**Rezoning Transportation Analysis**  
**Petition Number: Insert Zoning Petition #2021-232**  
*General Location Identifier: 15717307*

Date	Description
02-17-2022	First Review (WB)

The site is located on Randolph Road, a City-maintained major thoroughfare. A Traffic Technical Memorandum (TTM) is needed for this site.

**RZ-1**

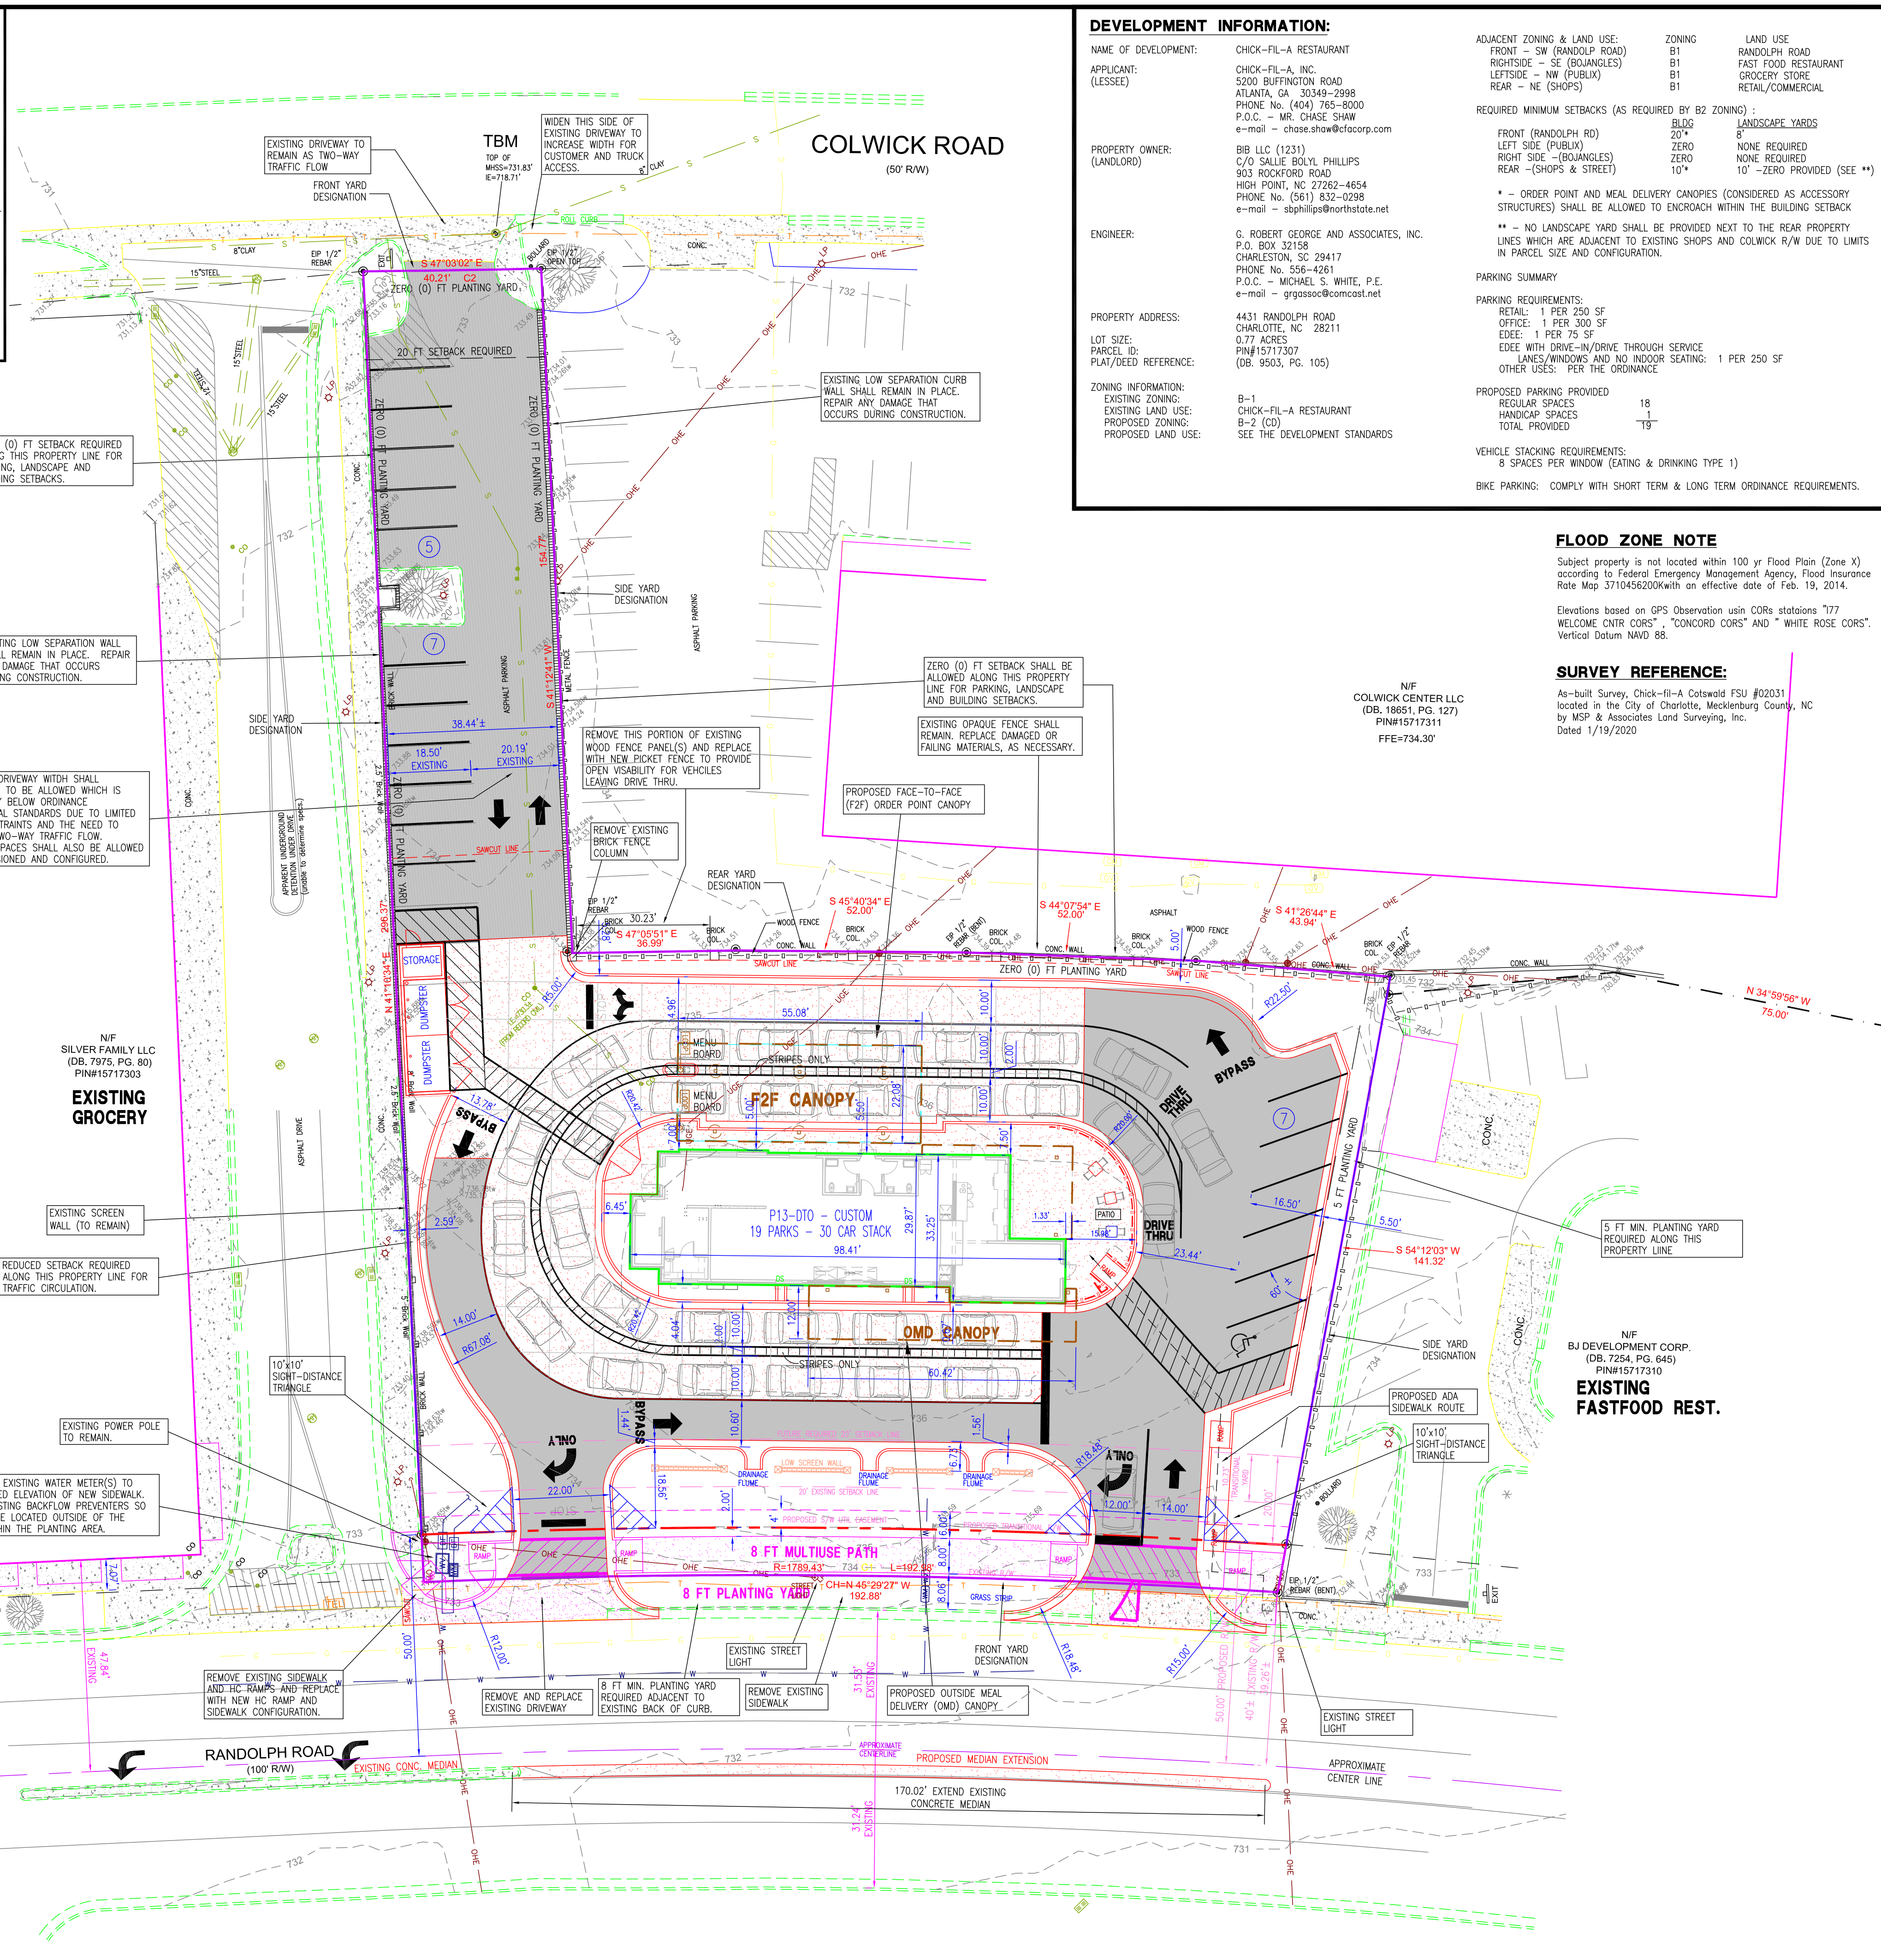
2. Revise site plan and conditional notes to commit to dedicate 50 feet of right-of-way from the Randolph Road centerline. The site plan shall label and dimension the right-of-way from the road centerline.

3. Revise site plan and conditional notes to commit to construct an 8-foot sidewalk with an 8-foot planting strip on Randolph Road per Chapter 19. The site plan shall label and dimension both items from the back of curb and gutter.

4. Revise site plan to provide a minimum of a 100-foot driveway stem, measured from the back of the driveway apron, into the subject site in accordance with the City's Driveway Regulations.

5. Revise site plan and conditional notes to provide an SUE (sidewalk utility easement) located 6-feet behind the propose 8-foot sidewalk to accommodate the installation of a future 12-foot multi-use path to meet the Charlotte BIKES Policy.

6. Revise site plan and conditional notes to commit to the complete removal of the existing driveway and proposed bollards.

7. Revise site plan and conditional notes to extend the existing concrete median on Randolph Road to a 50-foot offset from the driveway's curb return.
